Planning Application Ref: 3/2016/0269

Description of Development: Proposed agricultural building

Site Address: New House Farm, Grunsagill Road, Bolton by Bowland, BD23 4SQ

Floor Plan

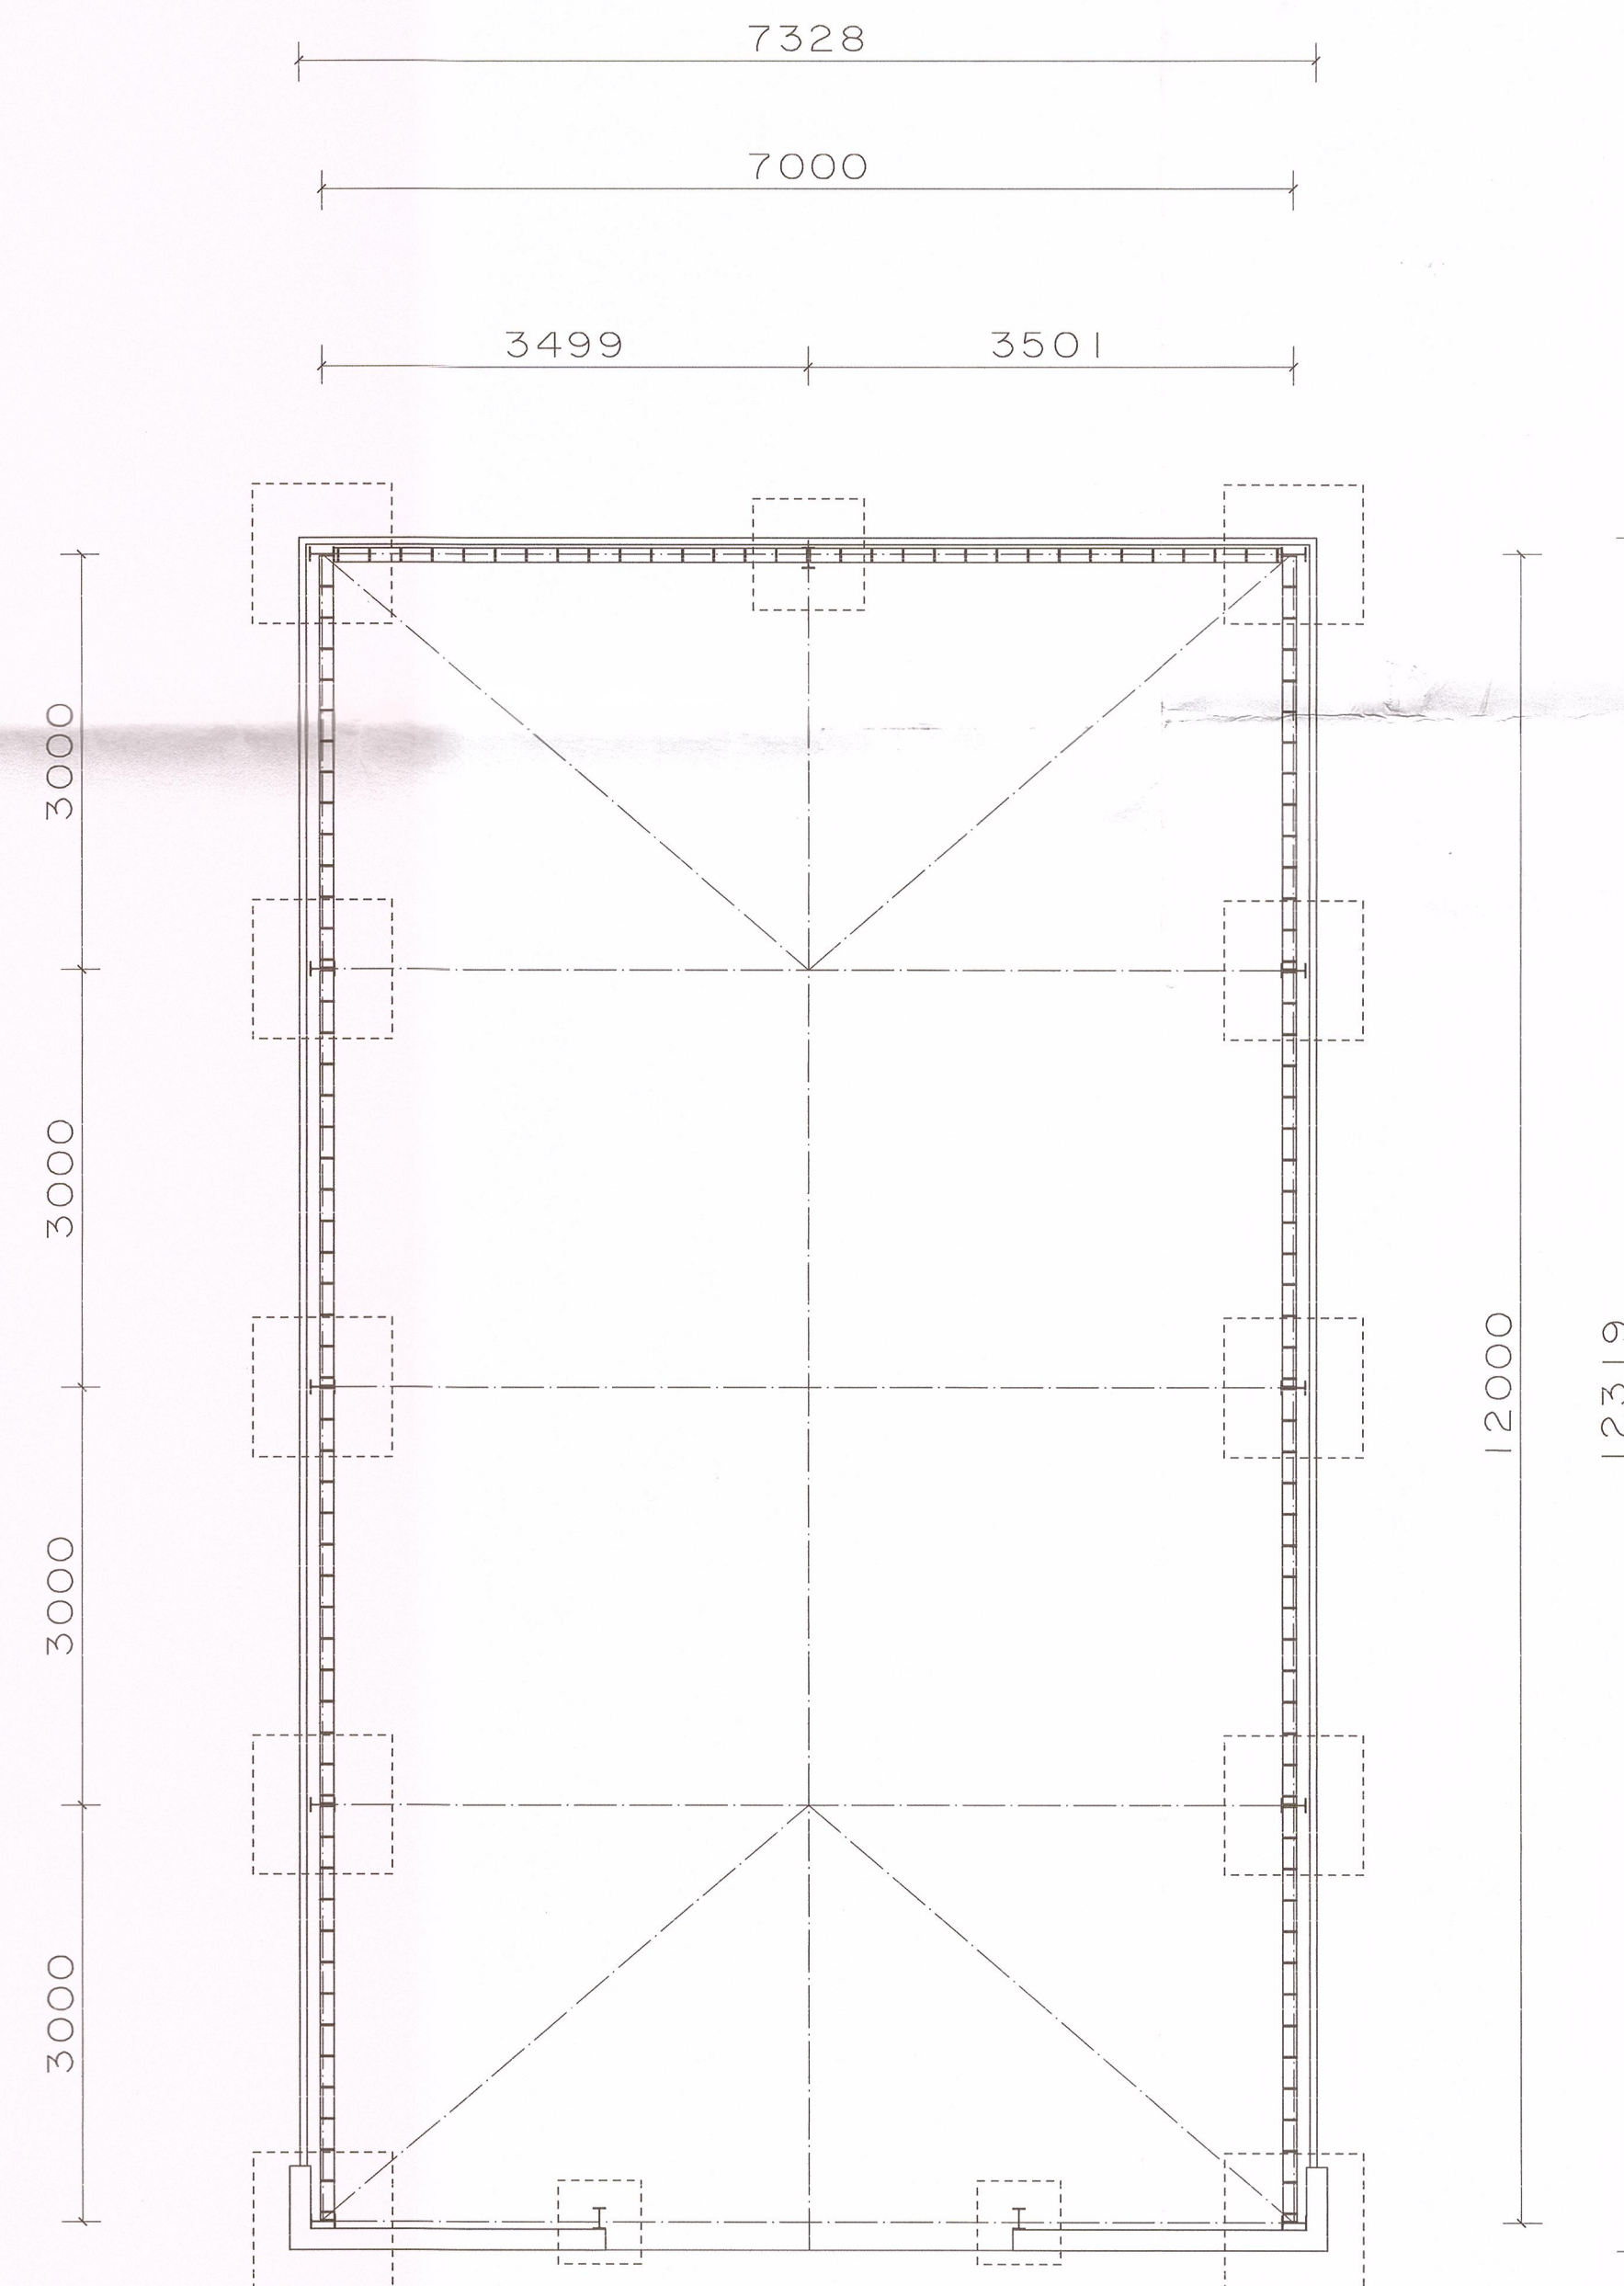
Agricultural buildings should be built to British Standards. If a building is to house livestock, which is suggested in the Planning Statement, then I would also question if the building is appropriate in its design. The British Standards for livestock buildings require construction to exclude harsh weather and draughts but provide maximum ventilation. I am concerned that the building, as designed, would not meet this requirement because of the blockwork walling, clad with timber externally and the stoning of the front of the building.

The site is located within the open countryside and an Area of Outstanding Natural Beauty (AONB), therefore consideration should be given to policy guidance that covers development in the countryside and AONB. Policies contained within the Core Strategy advise that development should protect and enhance the character of the landscape and acknowledge the special qualities of the area by virtue of their size, design, use of materials, landscaping and siting (Policies DMG1, DMG2 and DME2). Notwithstanding the concerns raised above regarding the 'need' for such a development, there are also concerns that the proposed building does not appear to be of an appropriate agricultural appearance or scale for its intended use. The building has a very shallow roof pitch and raised eaves, resulting in very large expanses of wall (using single materials and colours) which increases the massing and appearance of the walls. The height of the one opening on the front elevation also appears to be restricted for the use of storing agricultural machinery and does not sufficiently break up the massing on this elevation.

Given the location of the building within the AONB, the design of this building does not enhance the character of the wider landscape or respect the local vernacular. The principle of the development does not appear to be in line planning policies or guidance contained within the Agricultural Buildings and Roads, Supplementary Planning Guidance.

- There is a lack of evidence of agricultural activity at the farm (from the Case Officers site visit) and therefore a lack of evidence to support the need for a building.
- No evidence has been provided in the accompanying Planning Statement about how the building will be utilised by the applicant as part of the management of a viable farm.
- There are concerns that the design of the building provides appropriate ventilation to house livestock.
- There are concerns that the design of the agricultural building is not appropriate in terms of its scale, height and massing for its location within the AONB.
